From: Simon Davis
Sent: 26 April 2022 10:34
To: Planning Scanning
Subject: FW: Drove Lane, Yapton - Outstanding Drainage Condition Y/38/22/DOC

From: Simon Davis
Sent: 26 April 2022 10:32
To: 'Sparkes, Jessica' [REDACTED]
Cc: Havis, Sean [REDACTED]
Subject: RE: Drove Lane, Yapton - Outstanding Drainage Condition

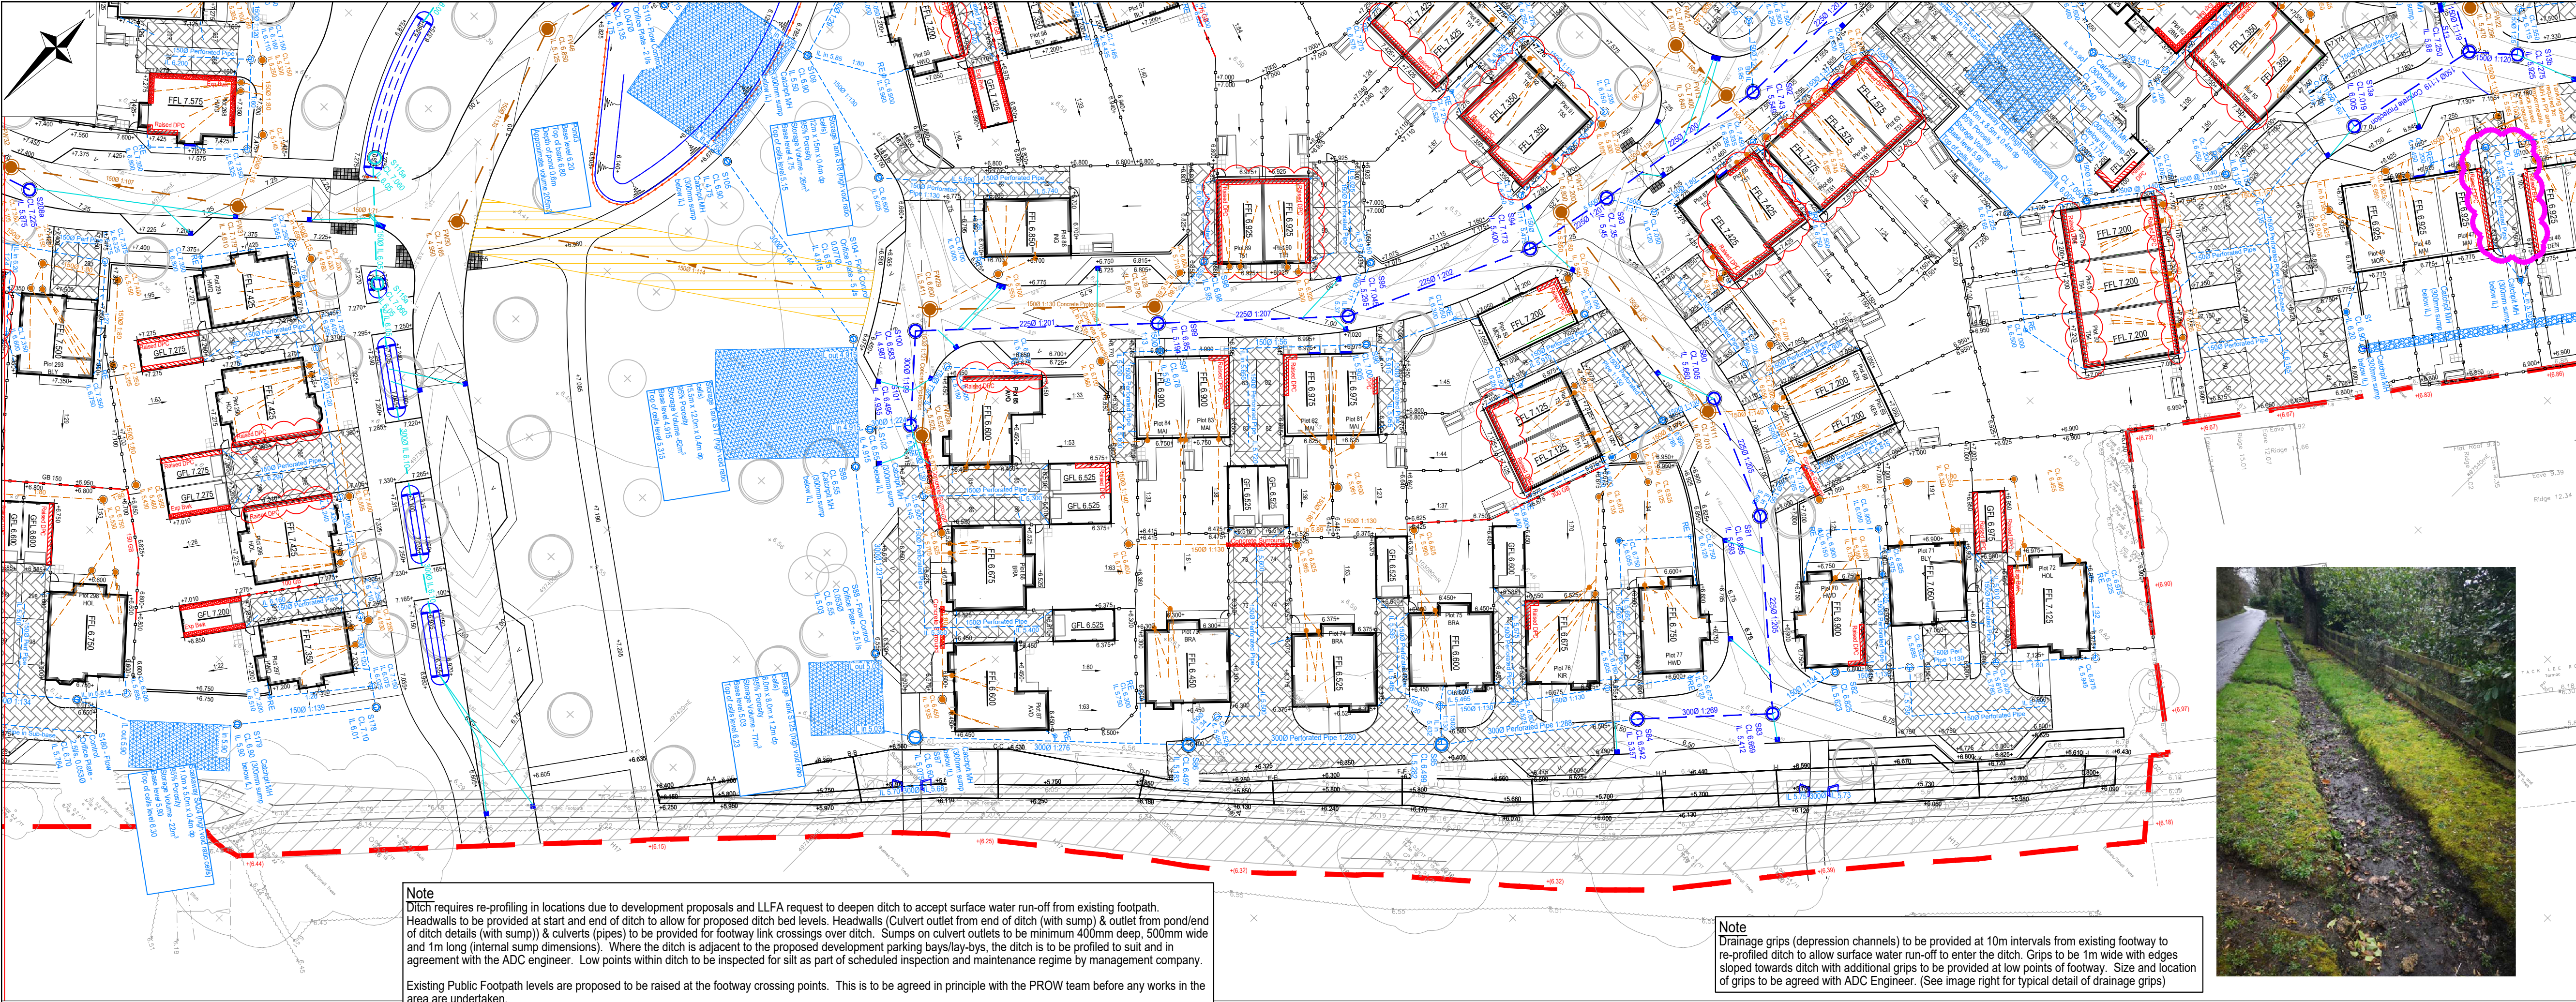
*".. Firstly, we are missing some information from your team regarding the following;
a- plans of the 'blind' east ditch – sections etc. I understand this is being used like a suds pond but with no outlet.
b)- headwall drawings - alterations have apparently been discussed and agreed but we don't have these yet.*
